SCOPING OPINION:

Proposed A46 Newark Bypass

Case Reference: TR010065

21 October 2022

DRAWING NUMBER HE551478	ORIGINATOR SKAG	VOLUME HGN	PROJECT REF NO. HE551478
CONWI_CONW	DR	LE	00003
LOCATION	TYPE	ROLE	NUMBER
			C01

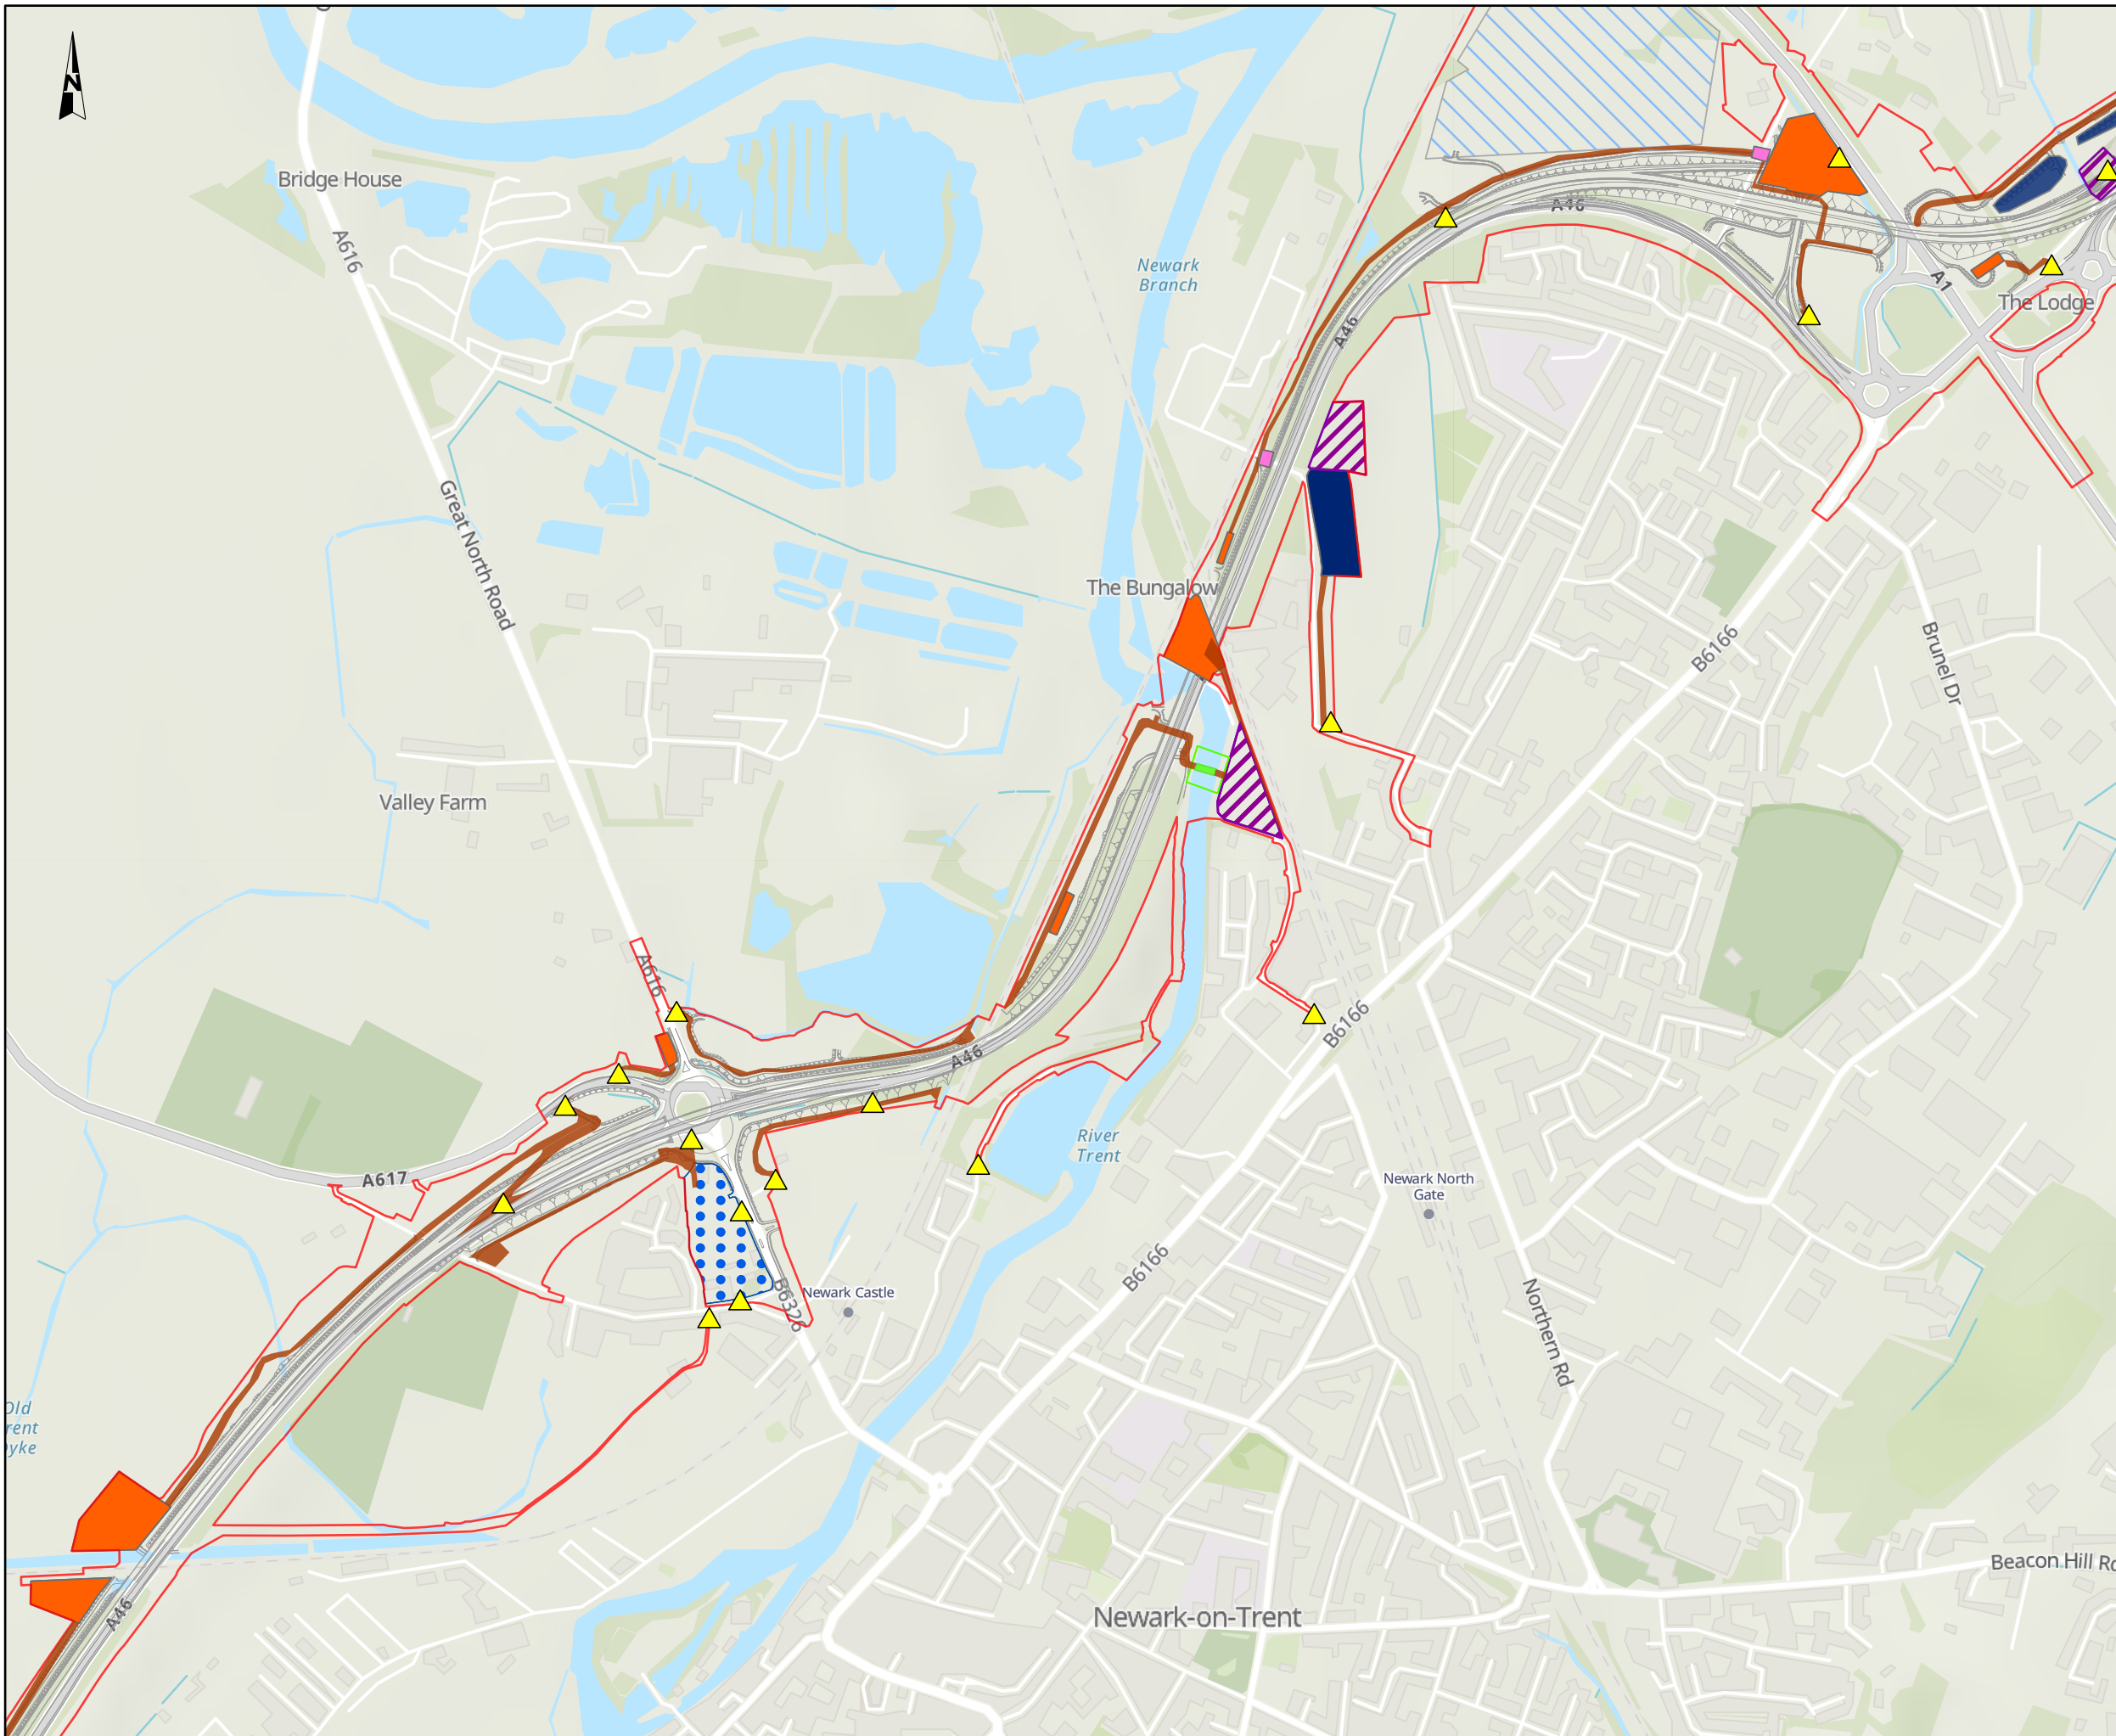
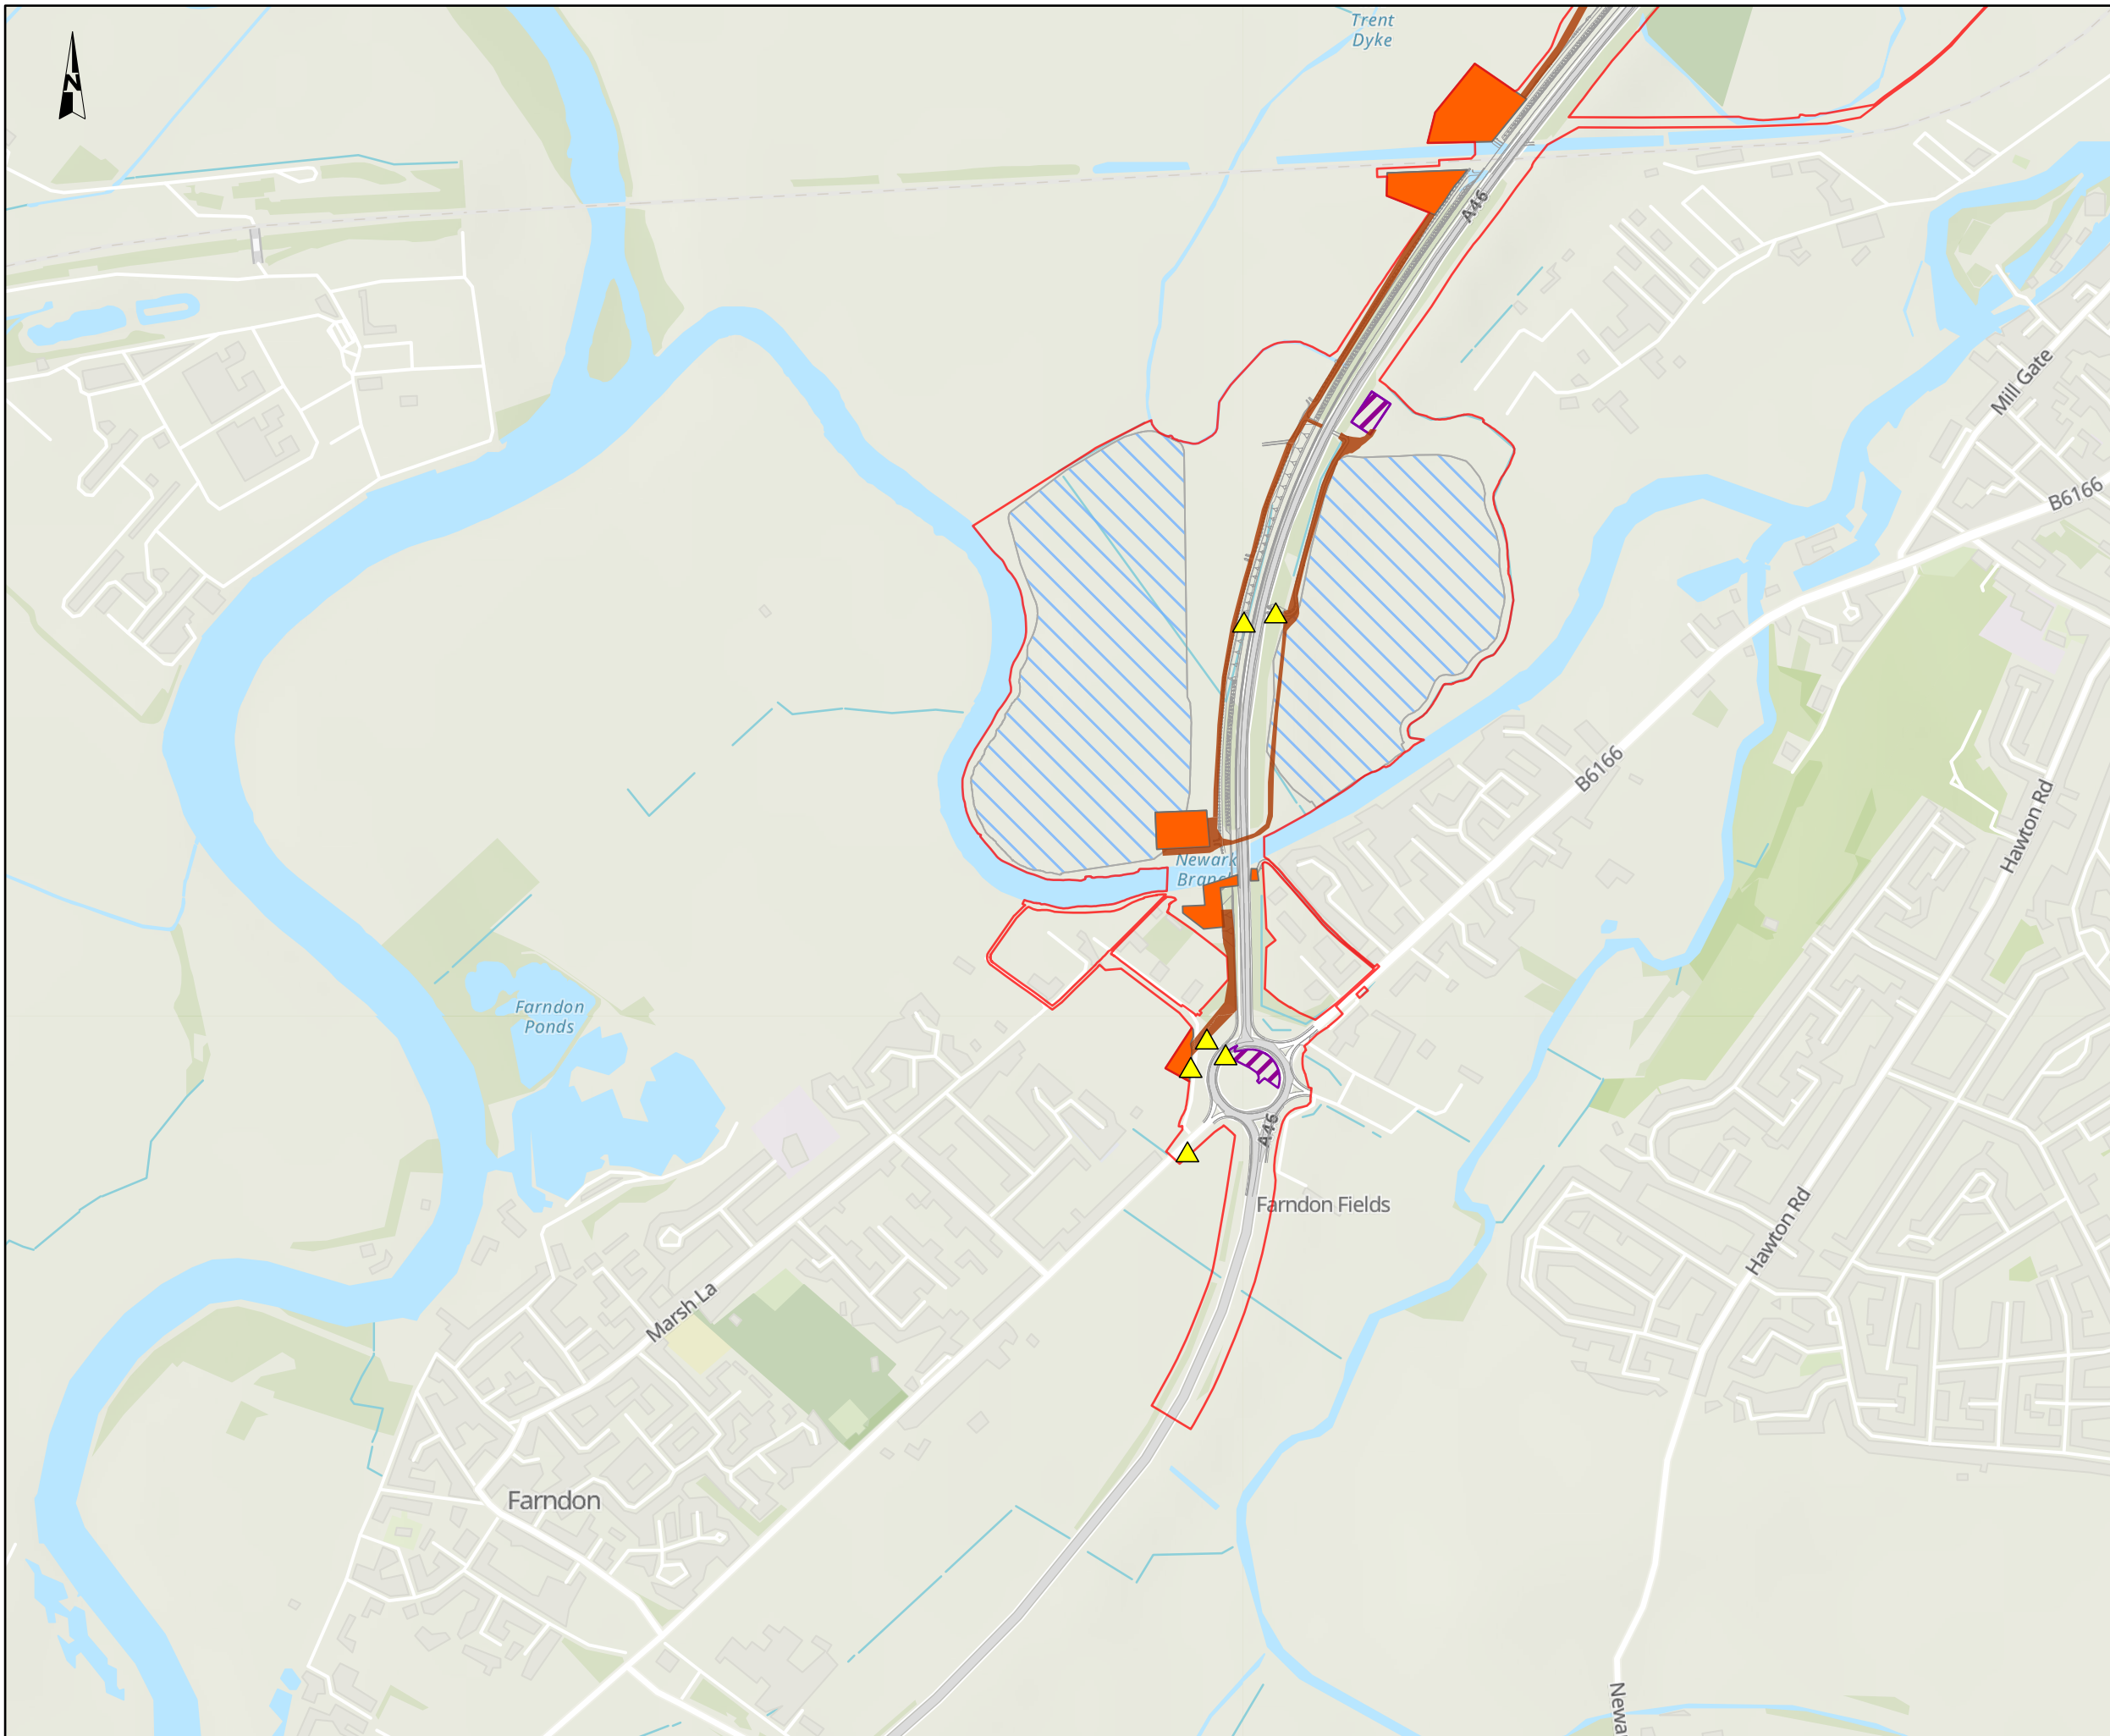
ID	Ref	Description	Inspectorate's comments
3.8.8	n/a	Temporary Works Areas and construction compounds	The Environmental Constraints Plan shows a number of areas identified as Temporary Works Areas. It is noted that these areas are located in Flood Zone 3. Furthermore, the Scoping Report states that construction compounds will be located outside of Flood Zones 2 and 3, however, it appears from the Environmental Constraints Plan that the indicative location for the main construction compound is located in Flood Zone 2 or 3 (not clear to see due to scale used) as are a number of proposed satellite construction compounds. The ES should provide further information regarding the nature of works required in these areas and contingency measures to be implemented if the areas became unavailable in times of flooding.
